Markup Summary **Plat**

ENG-SF19004-R2-LOI-Redlines_Summary

ENG-SF19004-R2-FDR-Redlines_Summary

Markup Summary CDs

LOTS 36-41 STORM SEWER (PRIVATE)
SCALE 1"=30'

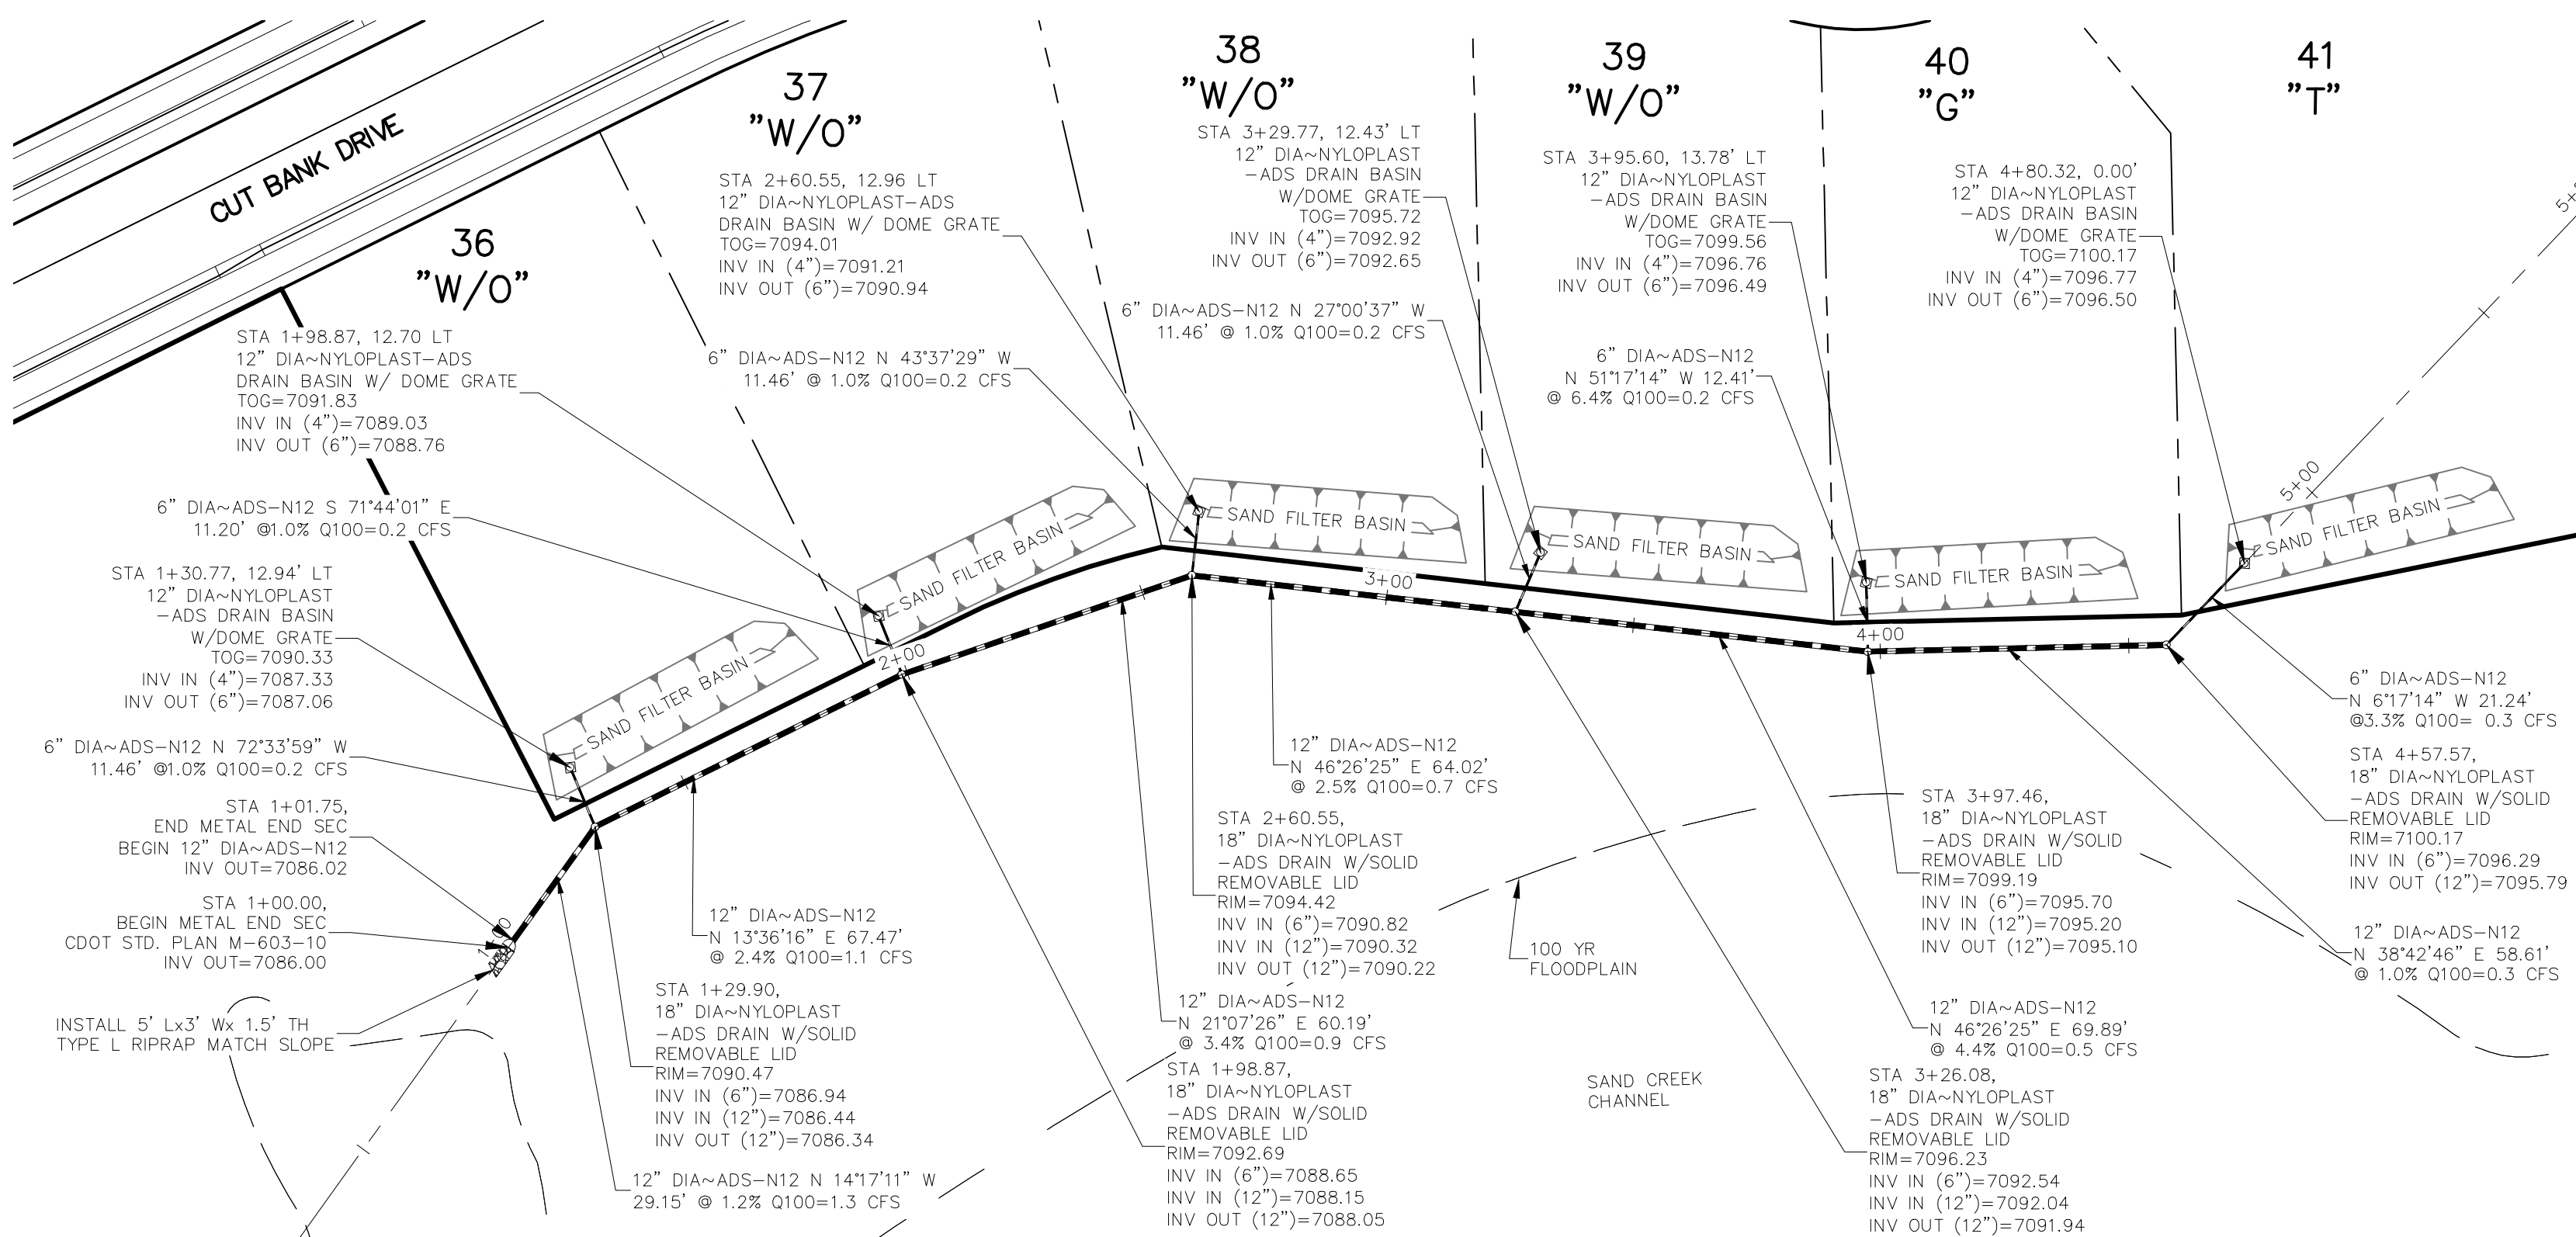
It appears that more stabilization (or spreading mechanism) is needed to the channel bottom.

Clearly show and label the proposed trail through the site.

Will the trail be utilized to access and maintain the SFBs?

provide maintenance access roads
